Gatwick Airport Northern Runway Project

Statement of Common Ground Between Gatwick Airport Limited and Tandridge District Council – Tracked Version

VERSION: 2.0

DATE: JUNE 2024

Diagram 3.3.9: Model performance before and after adjustment, London zone

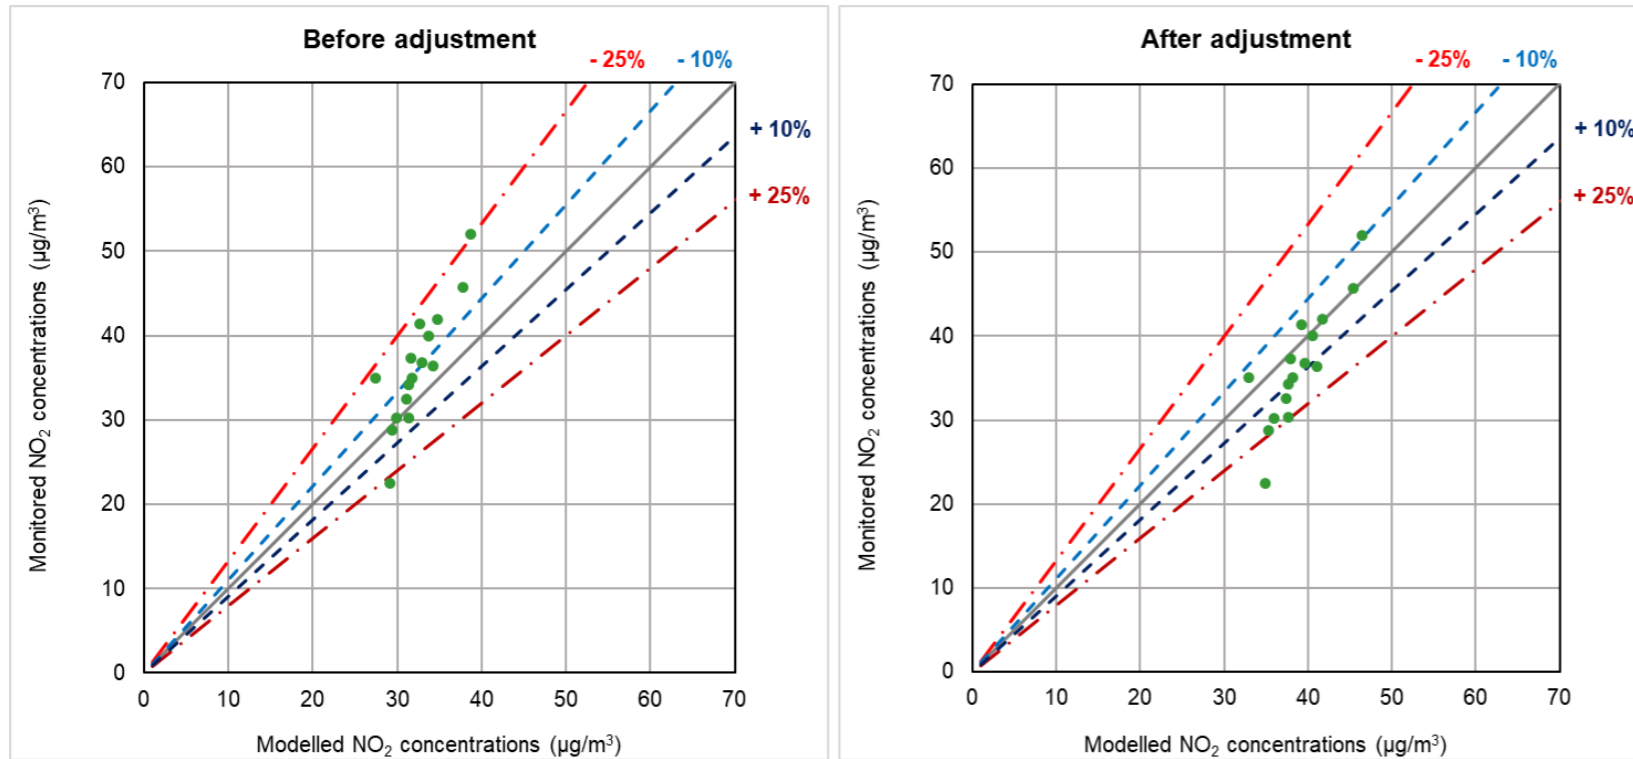
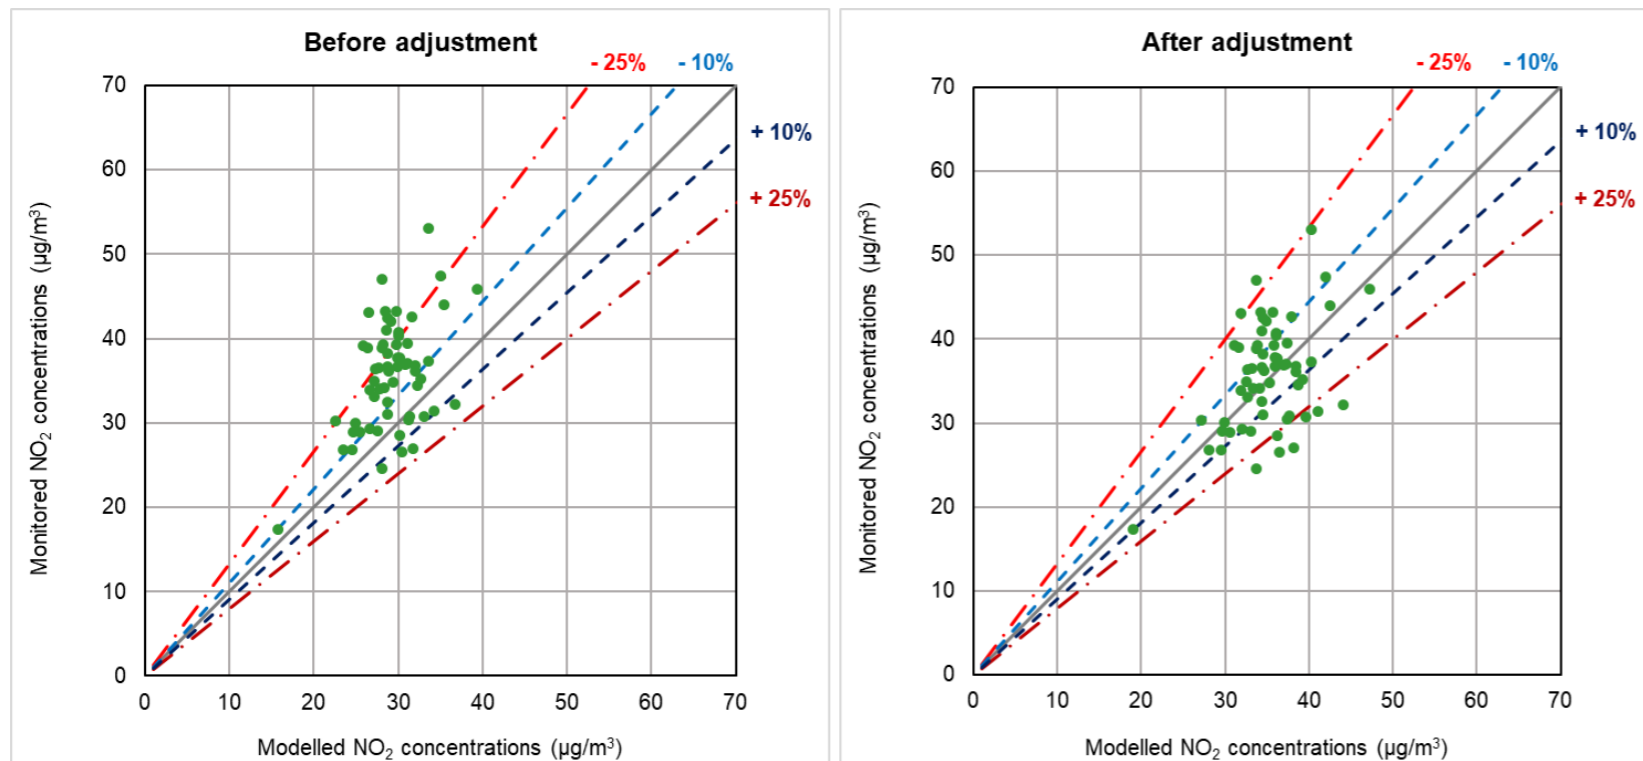
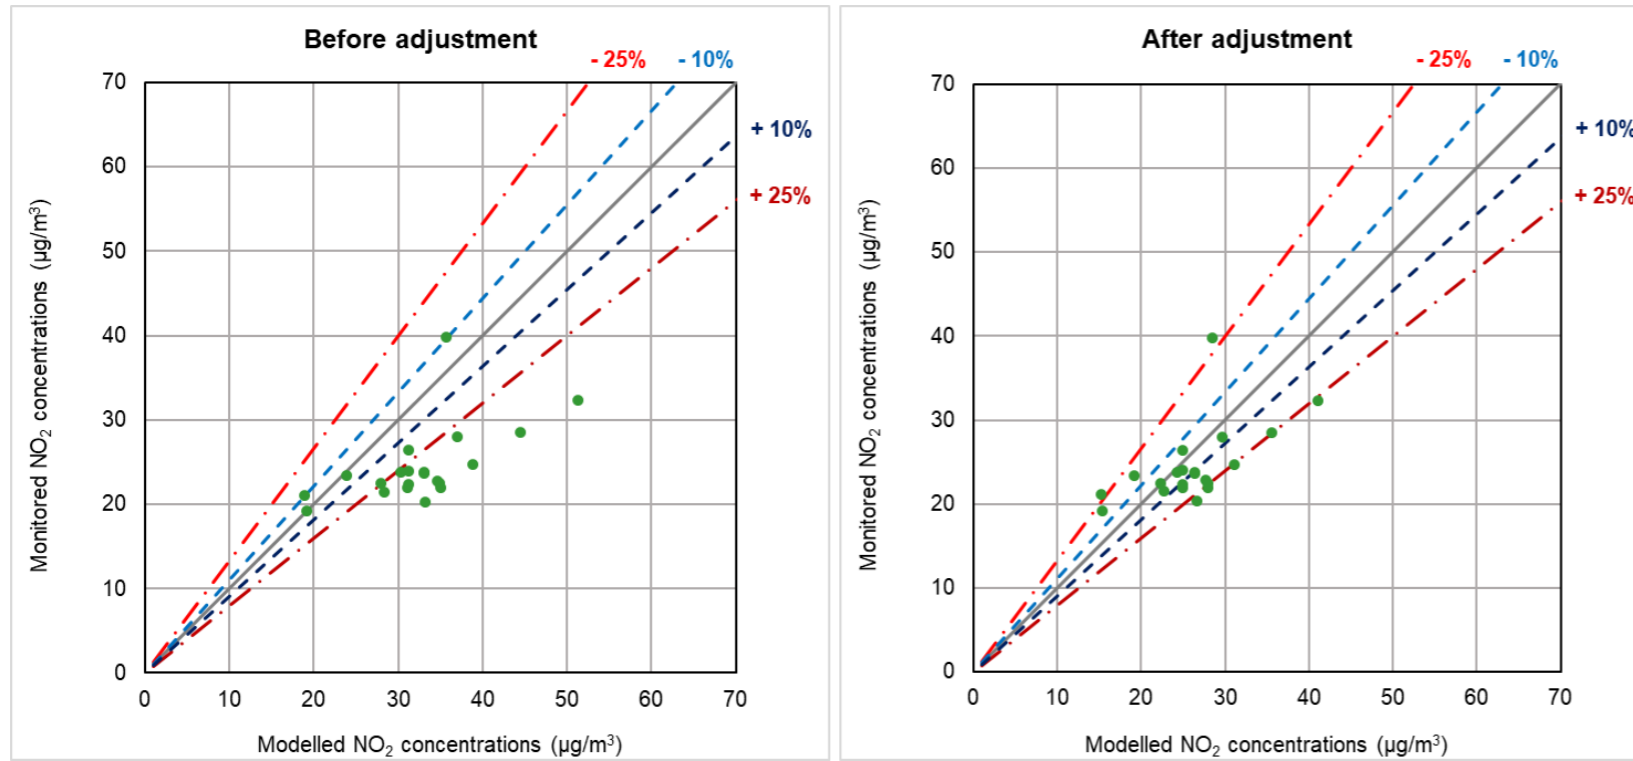
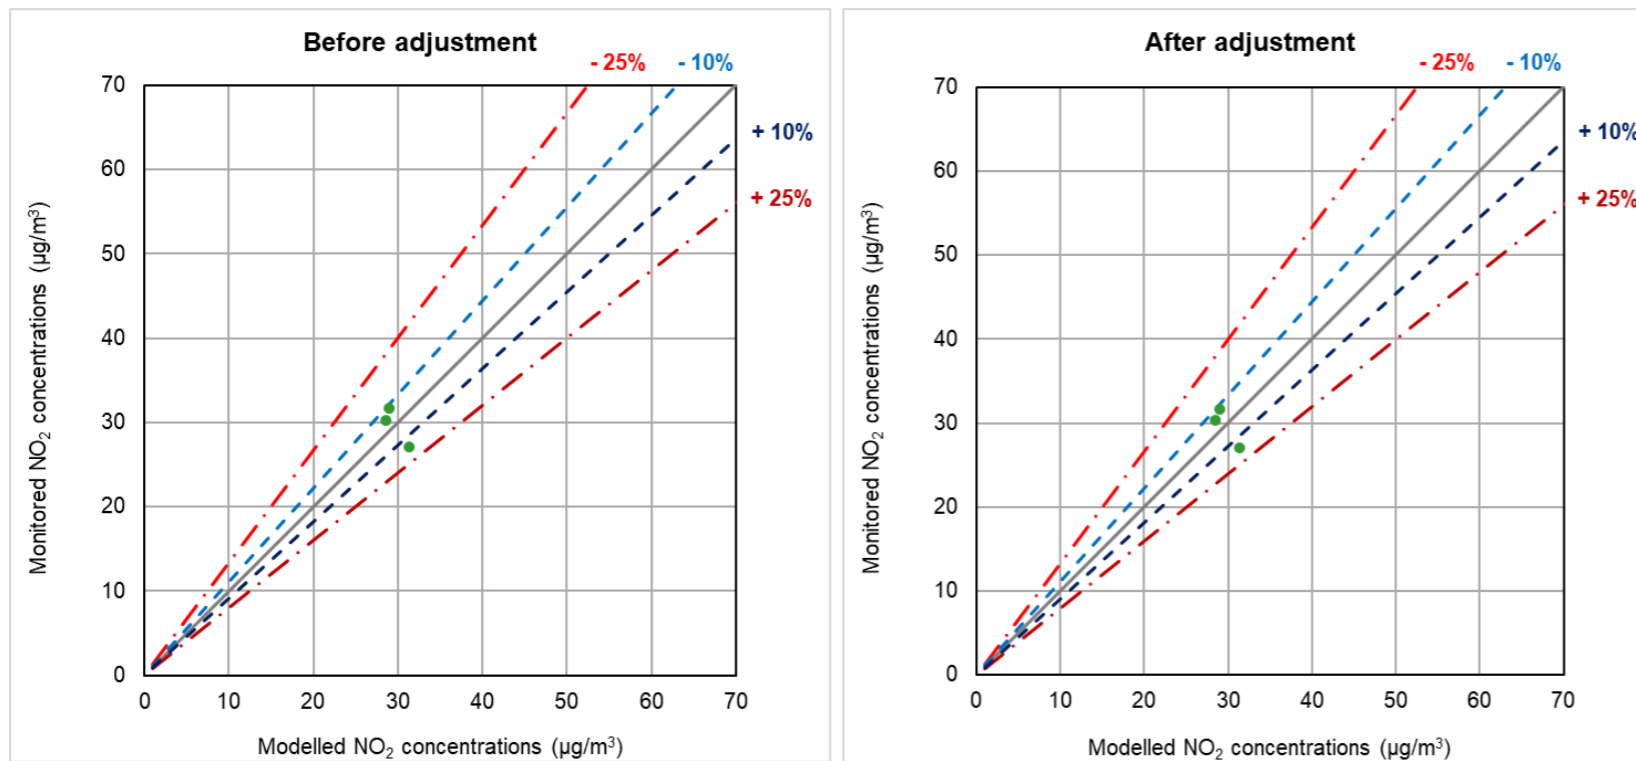
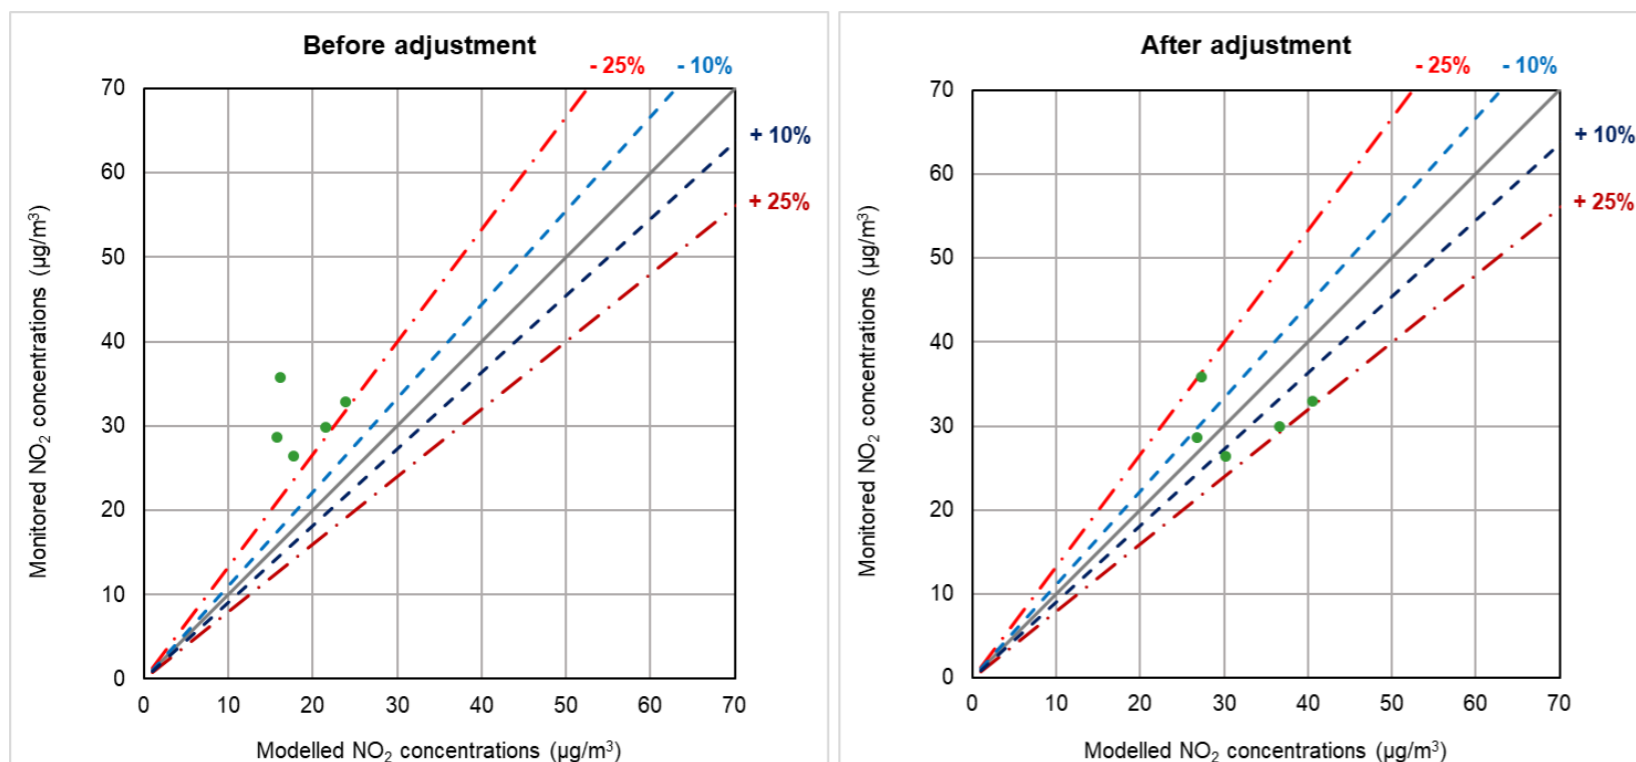
2.2.2.5	Verification zones	<p>TDC disagrees that enough justification was provided for the selection of different verification zones and why the model would be expected to perform differently in each area. A sensitivity test is required to</p>	<p>Full details of the model verification process are included in Section 3 within the ES Appendix 13.6.1. Table 3.3.1 provides details on the verification zones used.</p>	<p>ES Appendix 13.6.1 Air quality Data and Model Verification [APP-159],</p>	Under discussion

<p>demonstrate that the conclusions of the assessment would not change if a single verification factor were used.</p> <p>Updated position (Deadline 1): Further discussion is required on this point and the request for a sensitivity test examining the use of a single verification factor still remains.</p> <p>Updated position (Deadline 5): Gatwick Airport Limited (GAL) comments in paragraph 3.7.7 of their Response to Deadline 3 Submissions [REP4-031] that the air quality matters submitted by the Joint Local Authorities at Deadline 3 (Appendix A) [REP3-117] will be responded to by Deadline 5. This Appendix of air quality queries prepared by AECOM included a wide range of technical matters.</p>	<p>The verification methodology was agreed with local councils at the modelling methodology workshop in November 2022. Model files and results were provided to the TWG via email 18th August 2023.</p> <p>The process followed during the ES took into account feedback from the local authorities at the PEIR stage and following discussions on the agreed approach.</p> <p>Updated position (April 2024): The Applicant notes that the JLAs have provided a submission on air quality at Deadline 3. The Applicant will review this submission and respond accordingly.</p> <p>Updated position (Deadline 5): The Applicant has provided a response to the air quality matter submitted by the JLAs at Appendix A: Response to West Sussex Joint Local Authorities – Air Quality to The Applicant’s Response to Deadline 4 Submissions (Doc Ref. 10.38). The Applicant will respond at Deadline 6 to the JLAs’ review submitted at Deadline 4 [REP4-053].</p>	<p>Appendix A: Response to West Sussex Joint Local Authorities – Air Quality to The Applicant’s Response to Deadline 4 Submissions (Doc Ref. 10.38)</p>
